Belsay Awakes Play Layout  
- Annotated Changes

BY  
WH/TH

The middleton's plant collection

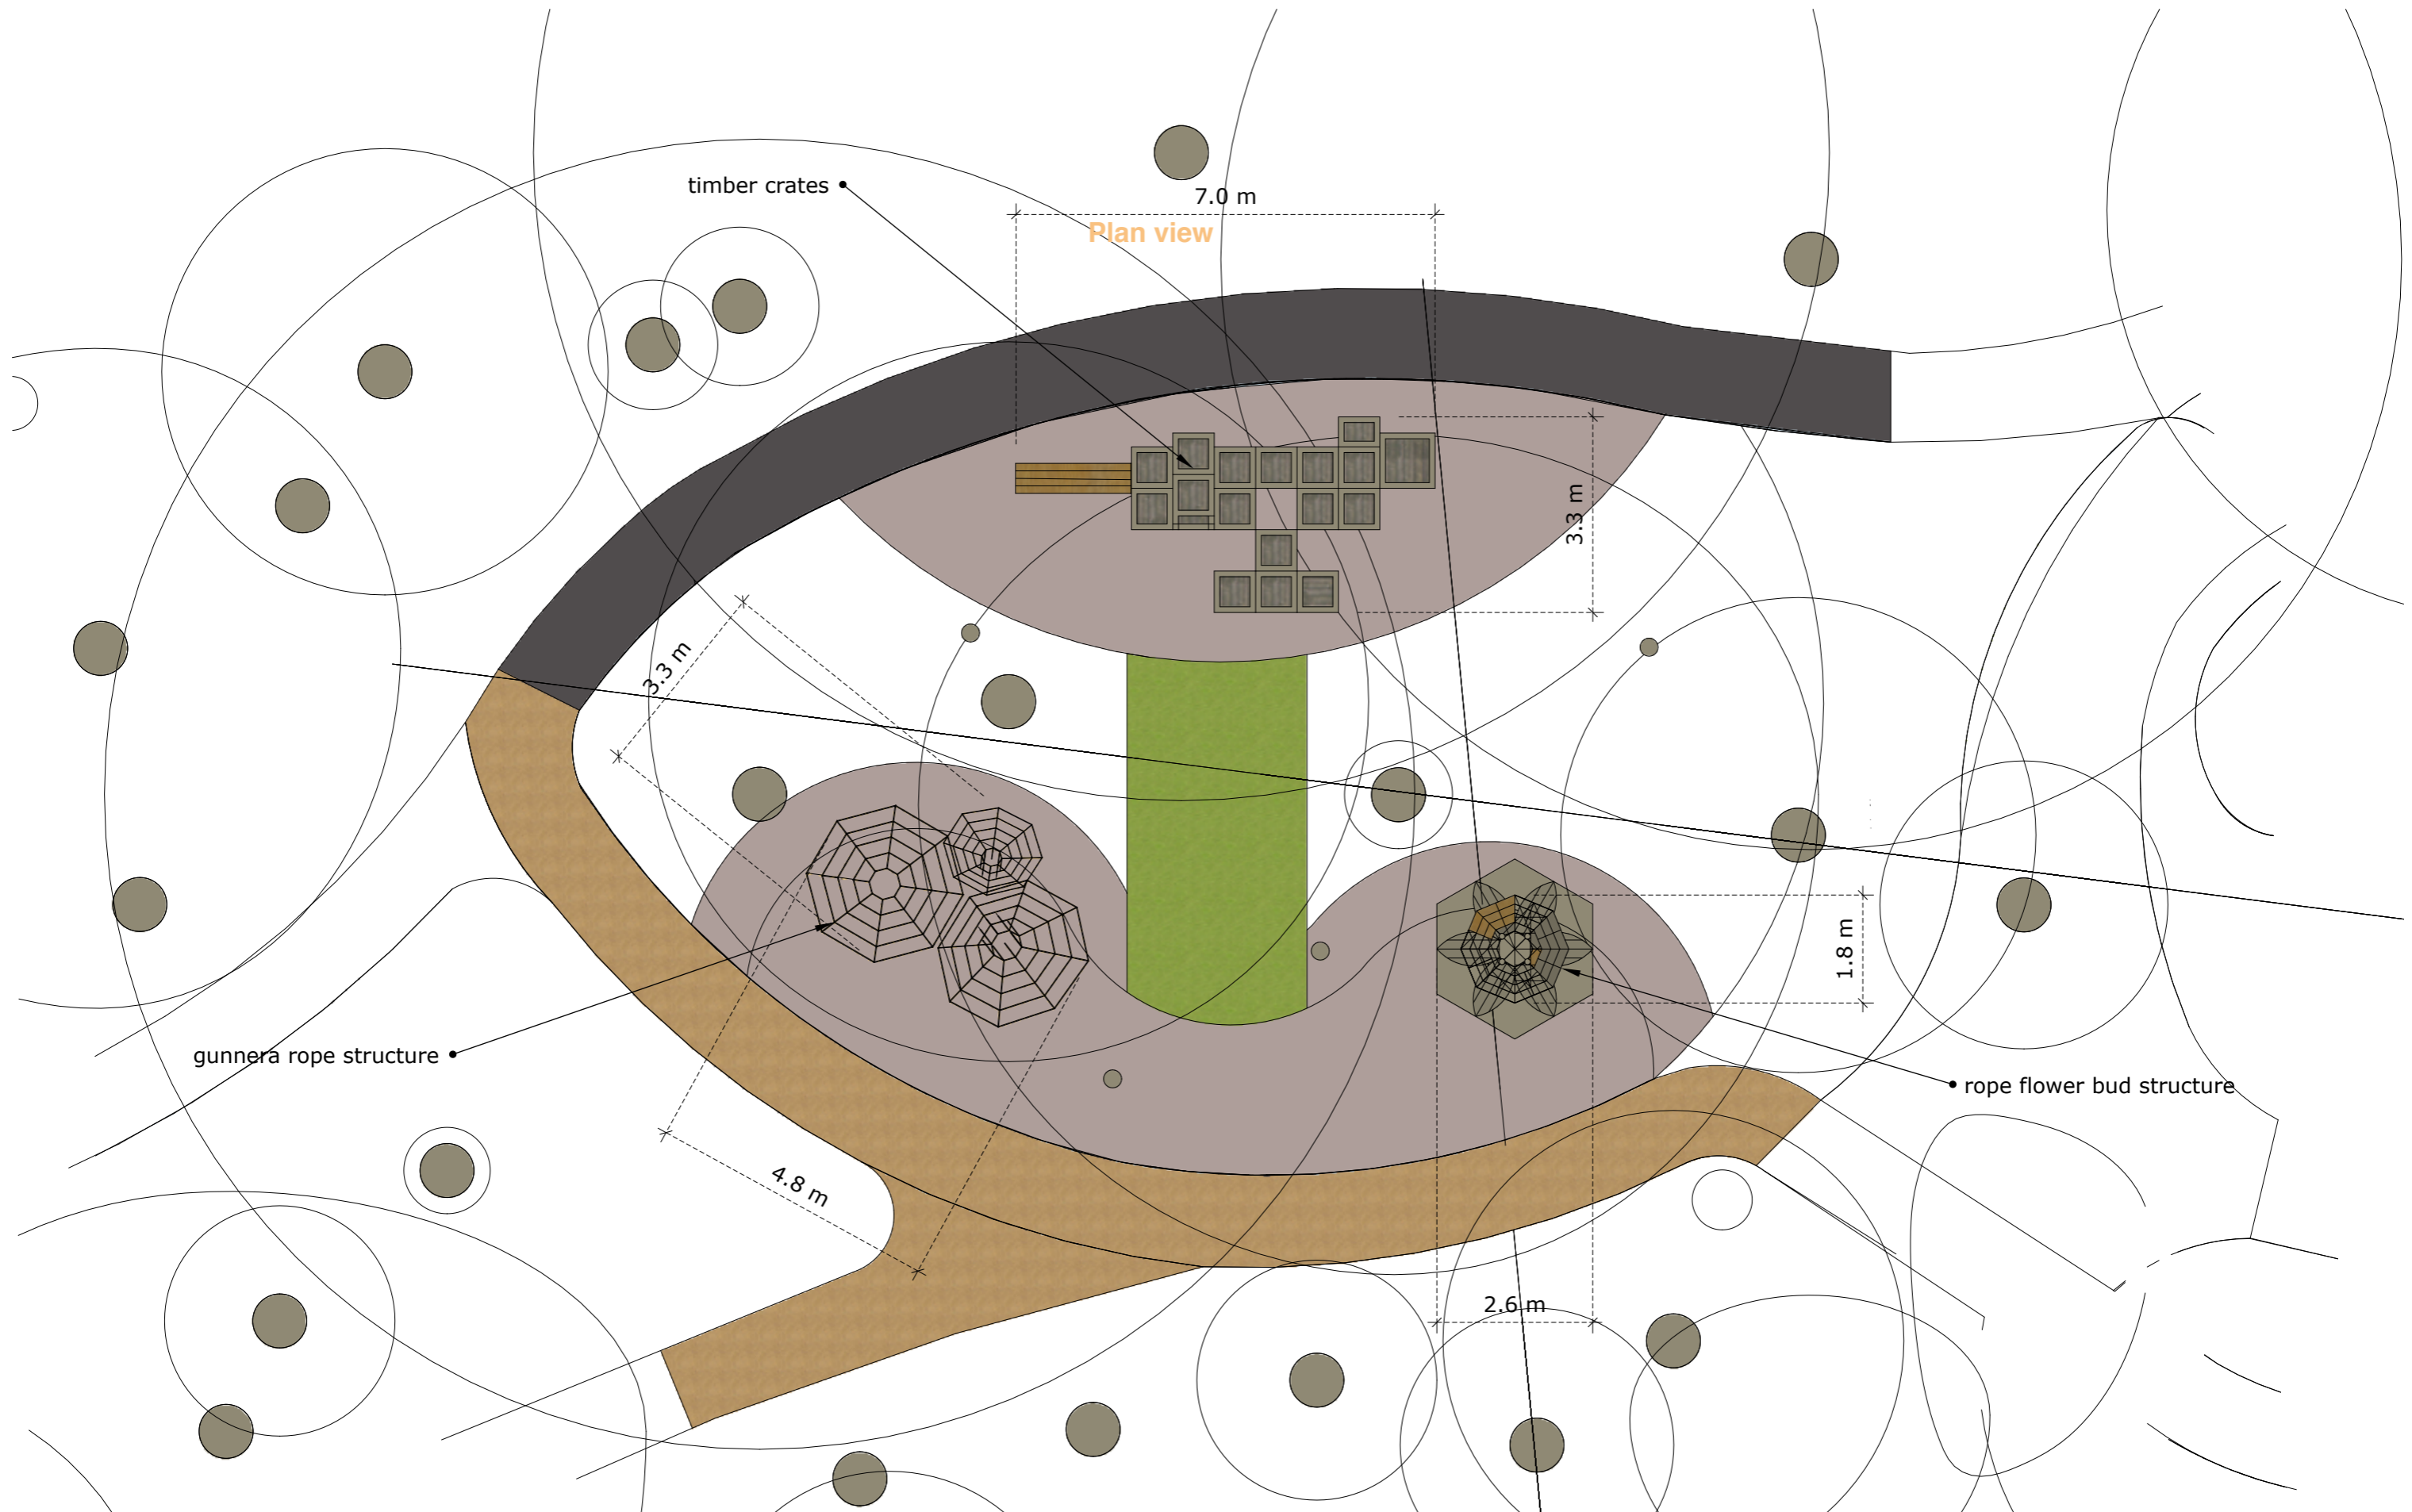
Cruck frame swings replaced climbing nets. Play crates no longer have access ramp.
